Harnett County
108 EAST FRONT STREET
LILLINGTON, NC 27546
Phone:
Fax:

SUBJECT: BRES2003-0023
BUILDING RESIDENTIAL

Here are the results of all Inspections located at **35 RED BUD CIR:**

1 Level 1
1/4" = 1'-0"

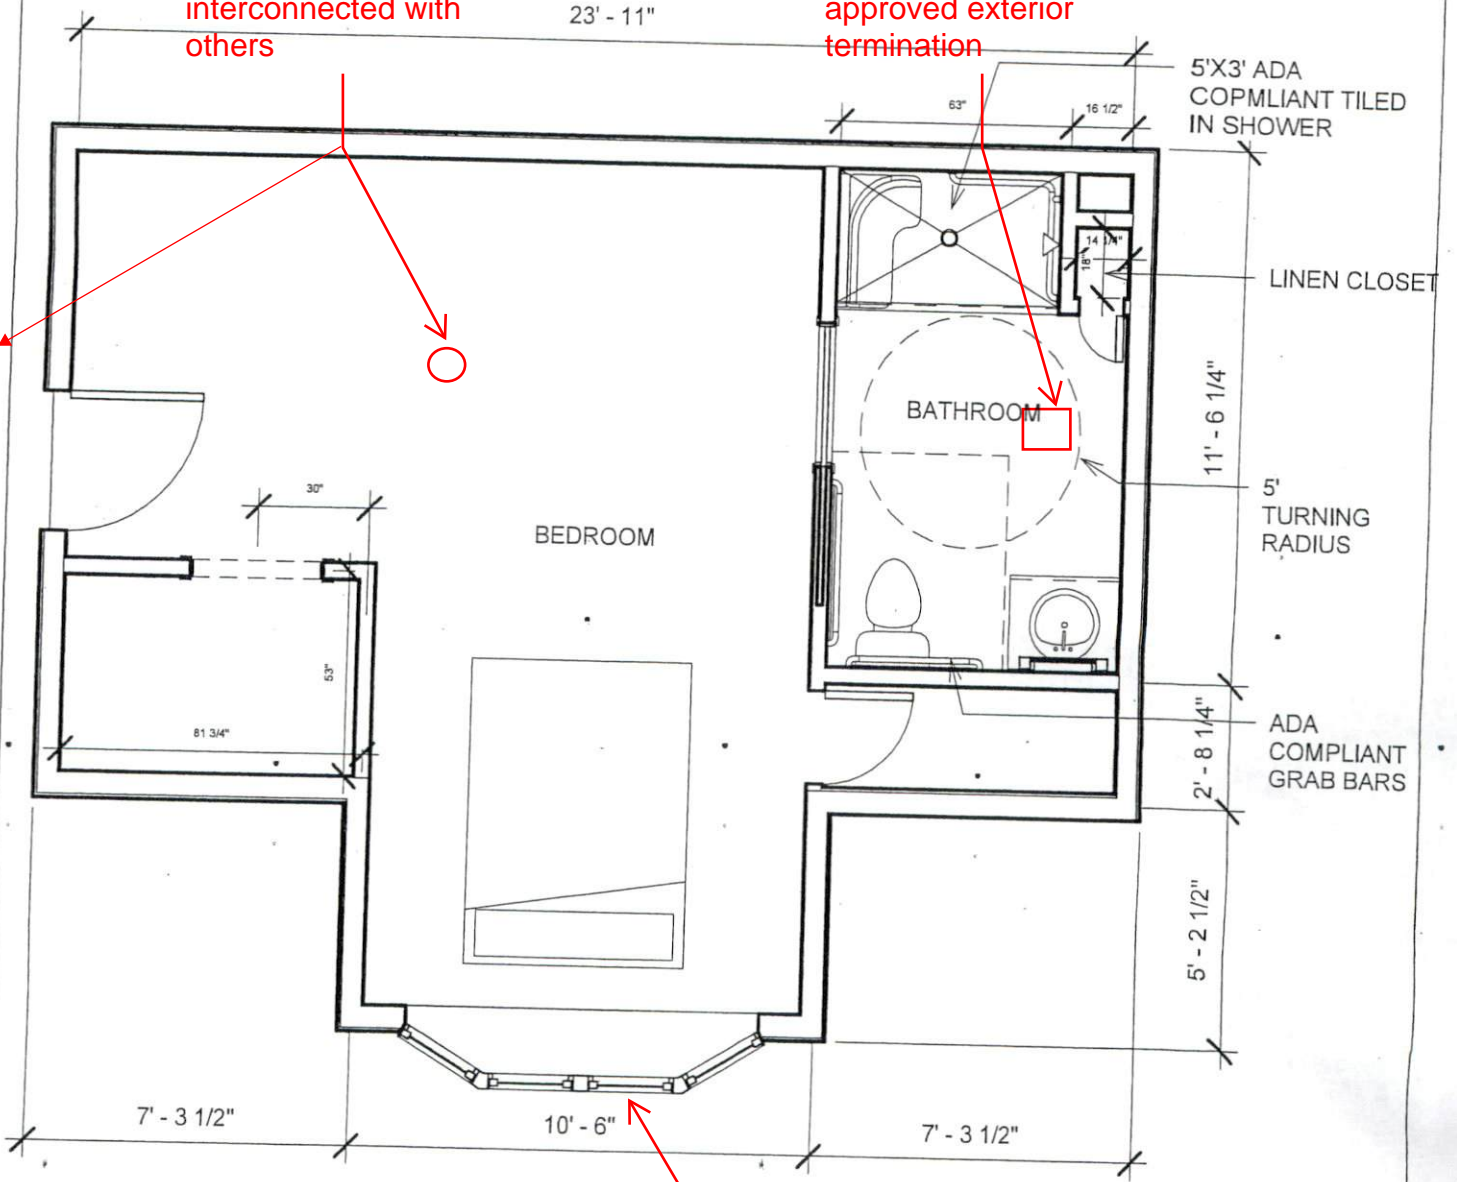
Inspection Type: ROUGH IN
Scheduled Date/Time: 6/5/2020
Completed Date/Time: 6/7/2020
Inspector: Slade Burton Lawson III
Result: DISAPPROVED
Remarks:
Notes: See approved plan in attachments
Cus will call to discuss LR
Move access opening out of shower, shower pan test down, head test down, seal around plumbing openings in garage, insulate p-trap garage, all inspections need to be called in at same time
